Appeal Decision

Appeal Ref: APP/C3105/W/22/3298098

Land to the south of Faraday House, Woodway Road, Sibford Ferris

Rev	Date	Details	Rev	Status
Project	Stage	Drawing		
4349	3	16	E	PLANNING

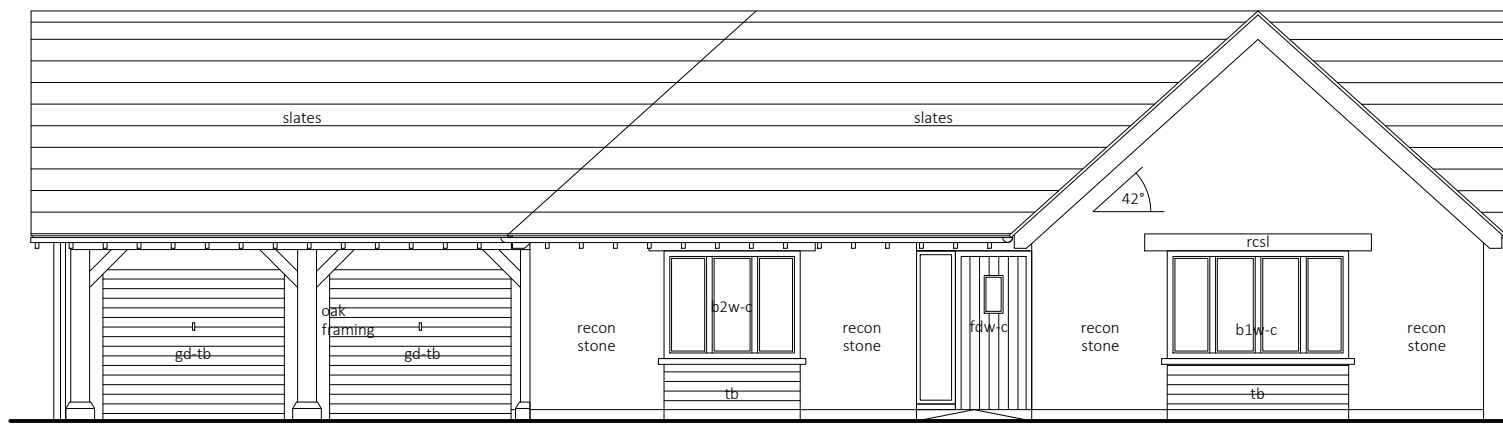
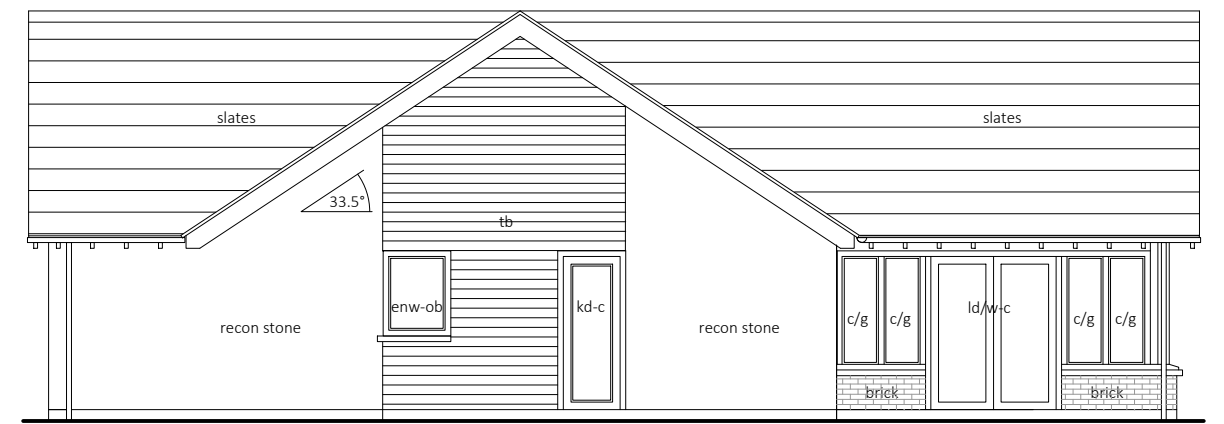
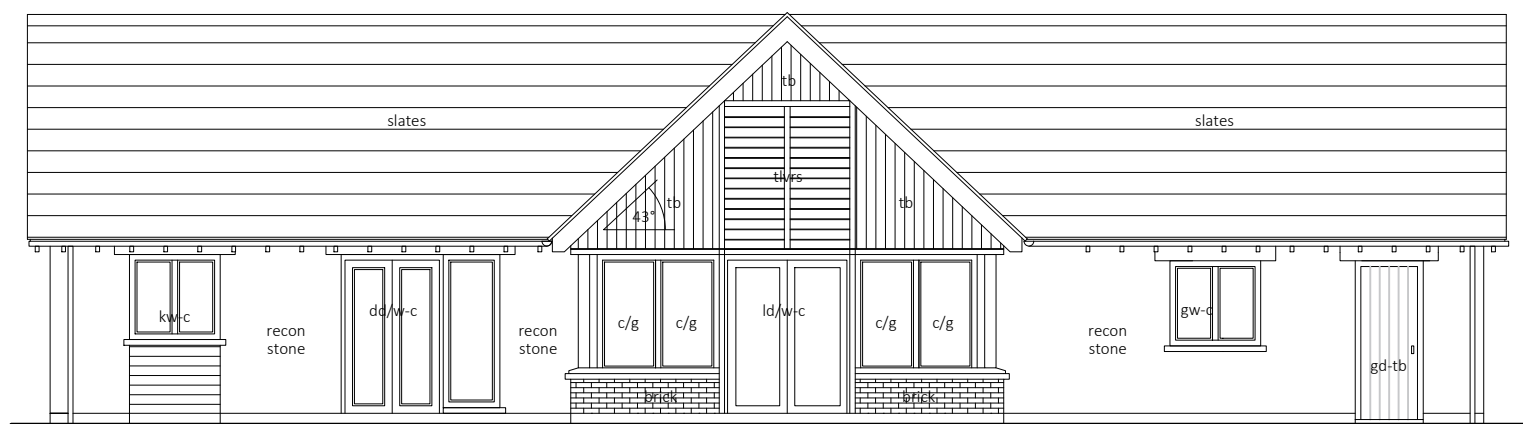
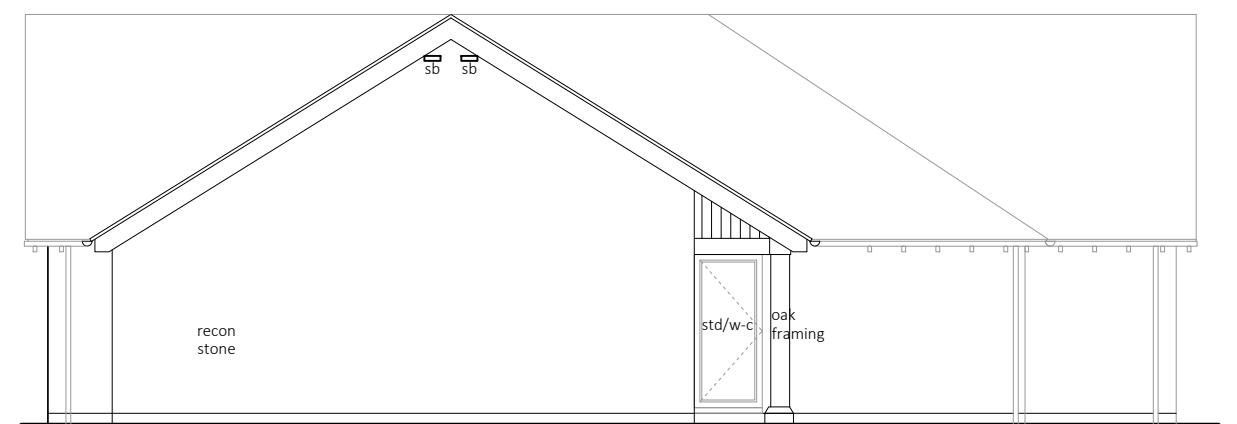
16. However, individual dwellings would have large footprints, varied pitched roofs, wide frontage elevations incorporating double garaging (plots 2-5) and long rear elevations facing onto the countryside (plots 1 and 6) which would be dominating on their plots. Dwellings would have limited sized gardens relative to footprints and hard standings within their plots. The road layout would comprise significant areas of hardstanding for access, vehicle parking and turning in close proximity to the dwellings. Such proximity would leave little meaningful landscaping opportunity for the frontages of the dwellings, especially plots 1- 2 and 5-6. Due to closeness, the dwelling on plot 3 would have an awkward and cramped relationship with that of plot 2. Aesthetically, the dwellings would also be similarly designed and elevations would have an overly fussy pattern of external materials, with the timber cladding positioned in arbitrary manner.

dwelling on plot 1 would be particularly close to roadside hedge with a poorly articulated flank exposing it to view. There would be landscaping but given the rising topography, it would take a considerable time to screen and filter views of the development from the countryside, including the public right of way along and adjacent to Woodway Road.
